July 5, 2023

RE: Special Use – Agricultural Exemption  
File: AL-23-008  
PID: 5100000264

Re: Proposed 11520 SF (72'x160') enclosed riding arena and feed storage to be located at 16845 Thompson Rd, Colorado Springs, CO 80908. Parcel # 5100000264. This is an 80 acre parcel.

Proposed  
Built Site

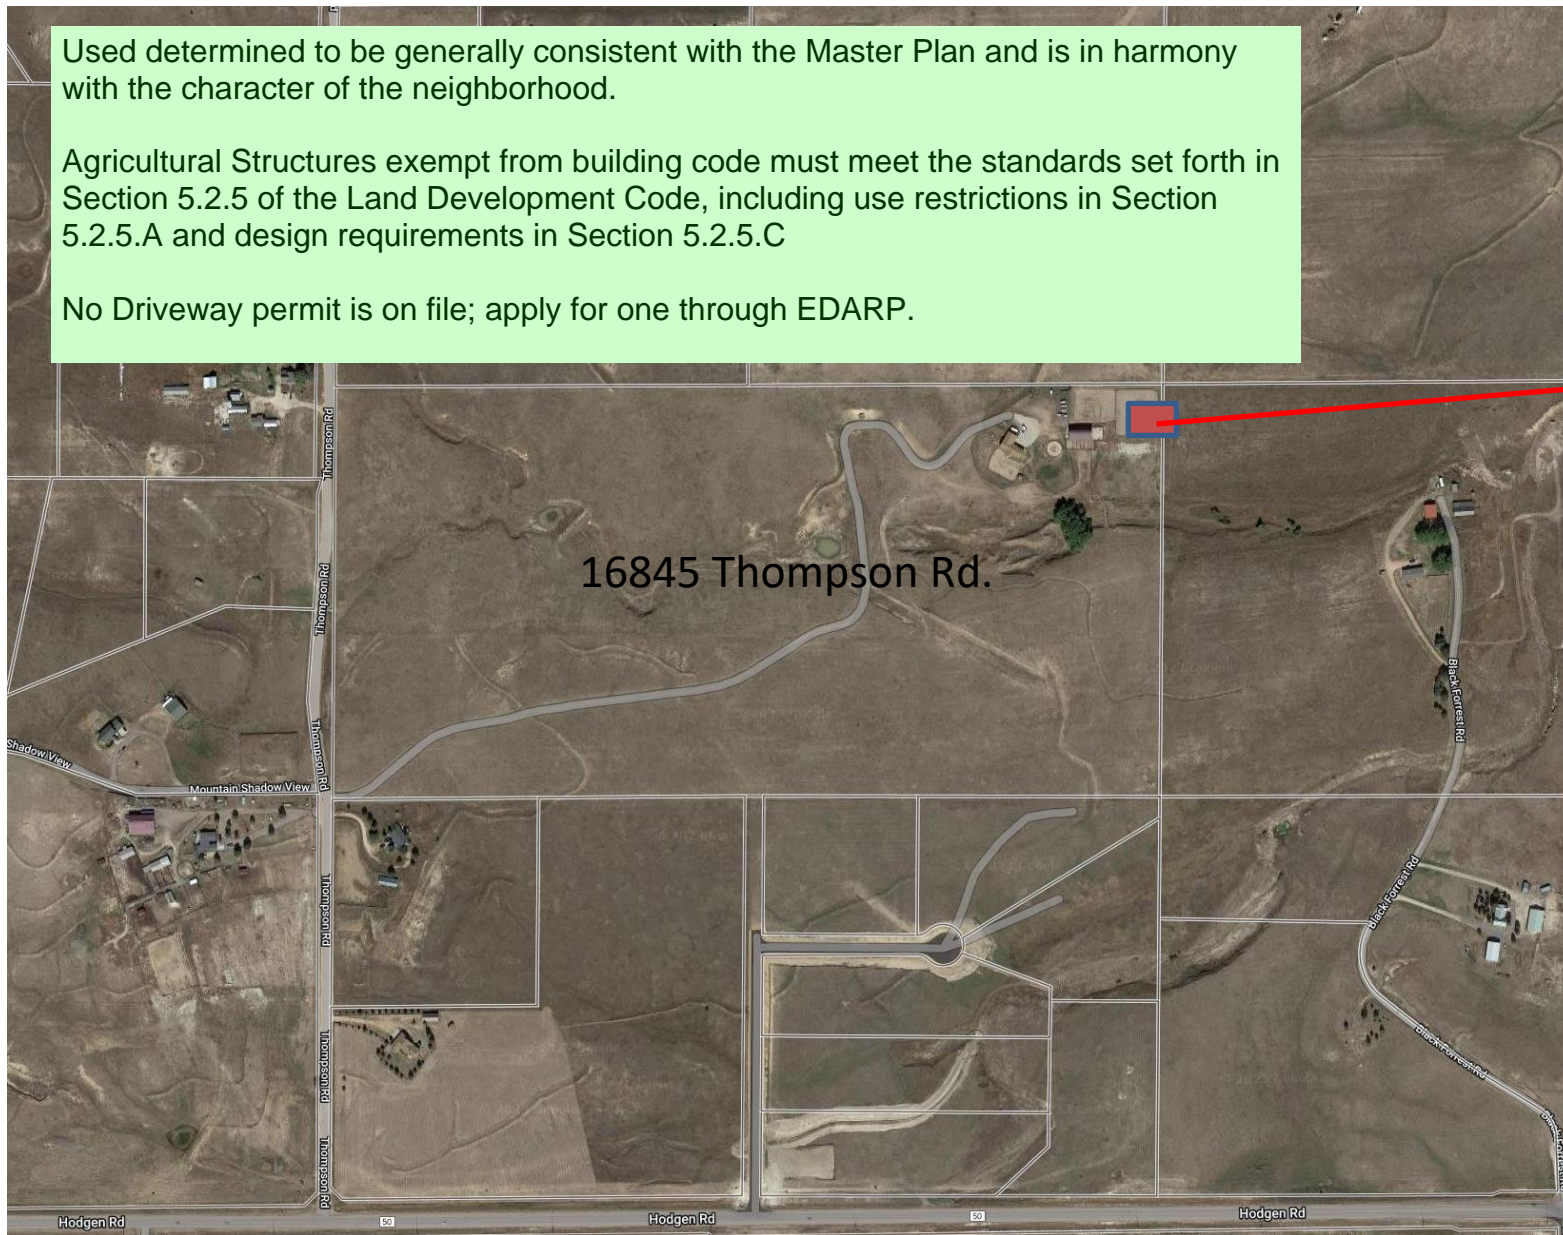
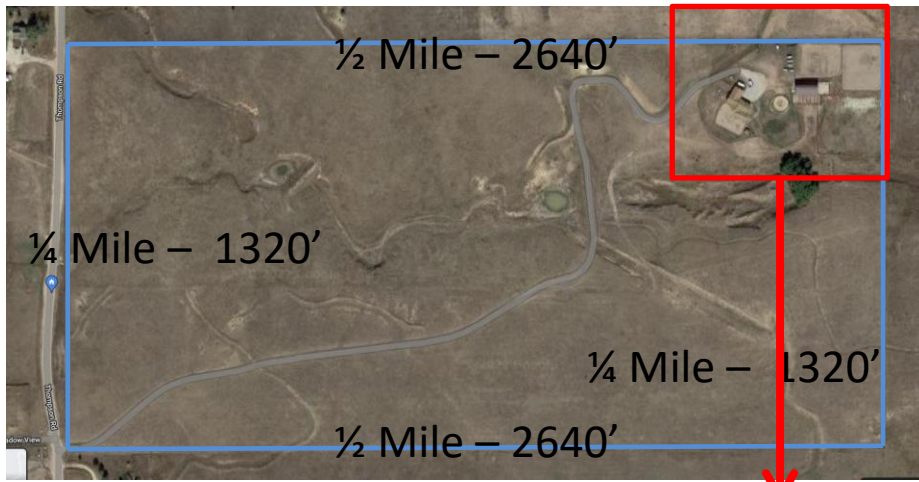
2. Driveway Access Permits are required for all access points onto a county road and there is no Driveway Access Permit on file for the existing driveway. Application for a Driveway Access Permit through EDARP (<https://epcdevplanreview.com>) is required.

No Driveway permit is on file; apply for one through EDARP.
